From: Mark Gutierrez <mark@giudicebuilds.com>
Sent: Friday, August 14, 2026 1:35 PM
To: Jen Uhler
Cc: efpdplanreview@gmail.com
Subject: Re: 1170 Spotted Owl Way / EDARP file AL2617 – Water Supply Documentation (Ellicott FPD Comment)
Attachments: Fw_ Contact Antelope Acres.eml; AA.pdf; 048 to A. Acres discharge pressure.xlsx
Follow Up Flag: Follow up
Flag Status: Flagged

Following up directly on Ellicott FPD's review comment for 1170 Spotted Owl Way (EDARP file AL2617):

SITE PLAN

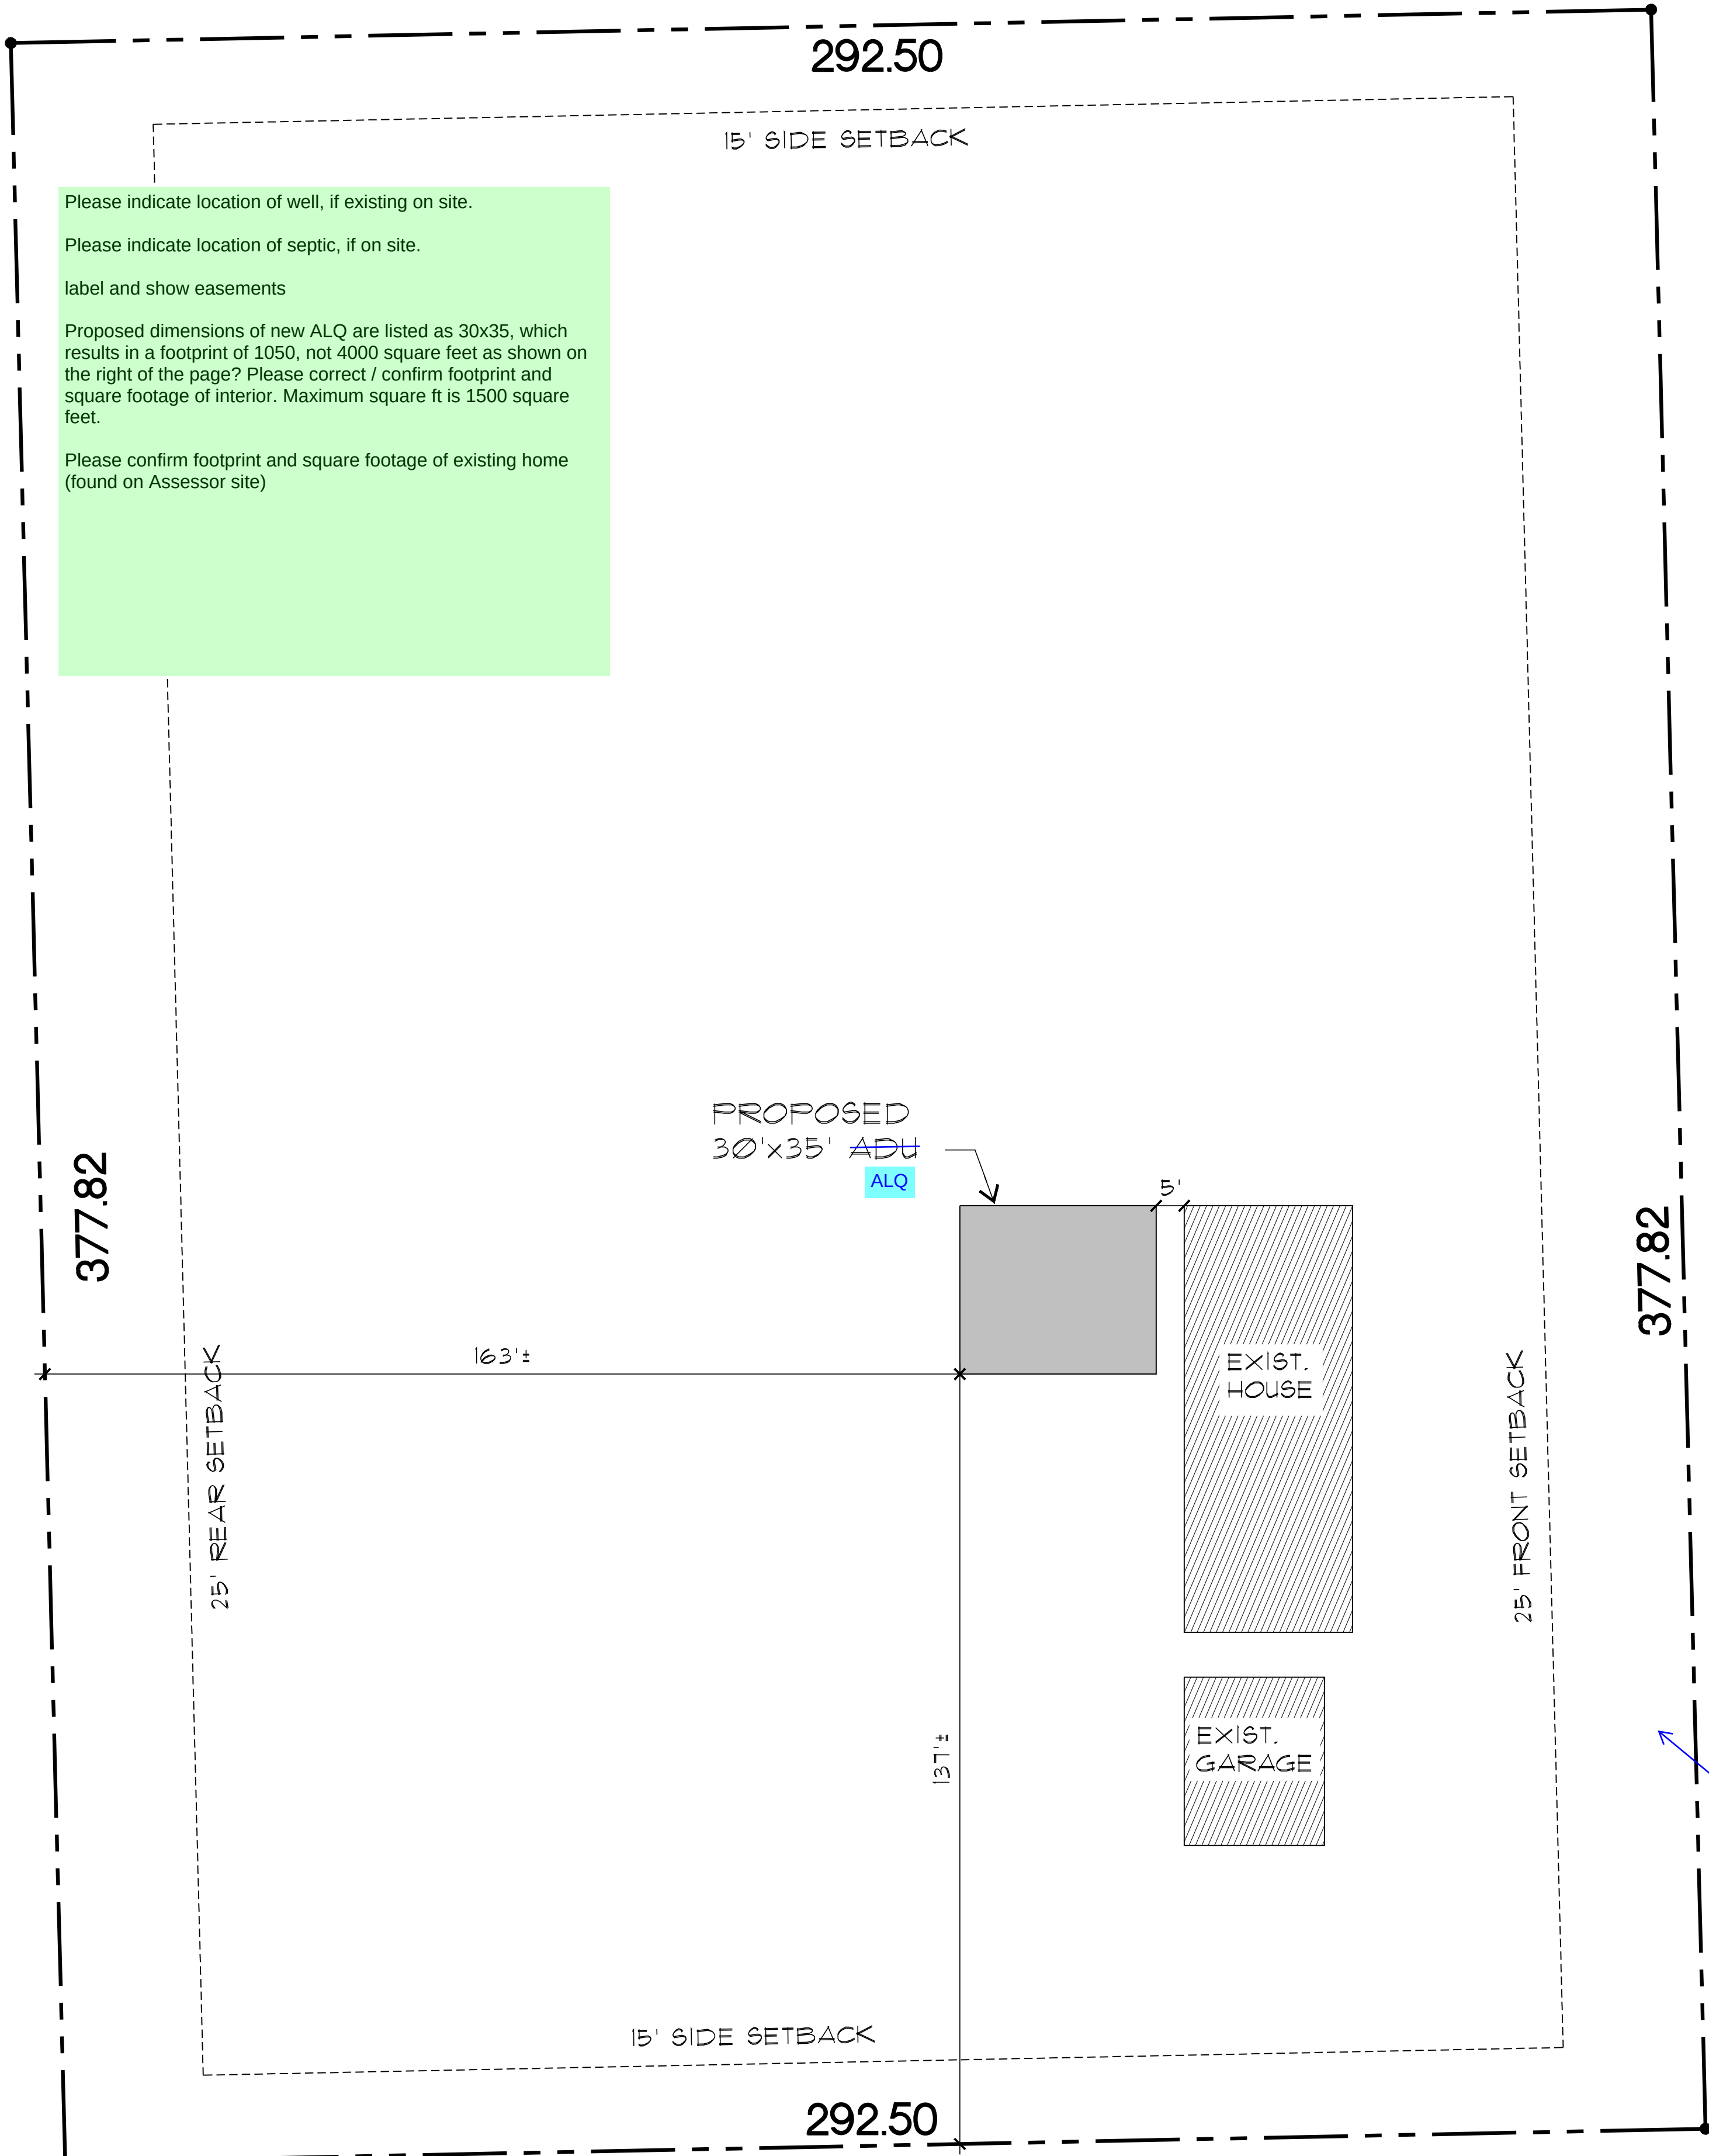
"The water requirement has not been addressed by the applicant or the planning department. The adopted fire code requires 1,750 gallons of water for a duration of 2 hours... All structures require water for fire protection per the El Paso County Land Development Code. No proposal of water or documentation of existing water supply has been provided... Per the El Paso County Land Development Code this additional dwelling unit would add 3,000 gallons to the existing water requirement for the property. Is the El Paso County Planning Department intending on collecting financial assurance for the required water supply for this project?"

Water source: There is no cistern serving this property - the source is the water tank in Mayberry (marked with the Ellicott Hawks logo), about 3,500 feet east of the branch-off point where water diverts to Antelope Acres, fed by Cherokee Metro's main booster station 3/4 mile away. This is a live, continuously replenished utility connection, not a fixed-volume storage vessel. Map attached (AA.pdf).

Discharge pressure: Using the water energy equation (accounting for elevation and friction loss from the booster station) and average summer flow data (May-July), Brandon estimates discharge pressure at the Antelope Acres branch at 187 psi. Supporting calculations attached (048 to A. Acres discharge pressure.xlsx).

Based on this data, the property's water supply satisfies the requirement Ellicott FPD raised. The adopted standard of 1,750 gallons over a 2-hour duration works out to a sustained flow of roughly 14.6 gallons per minute - well within the capacity of a pressurized municipal main running at 187 psi off an active booster station. Because this is a continuously supplied utility connection rather than a limited-capacity tank, it can sustain that flow indefinitely, which also covers the additional 3,000 gallons tied to the new dwelling unit under the El Paso County Land Development Code.
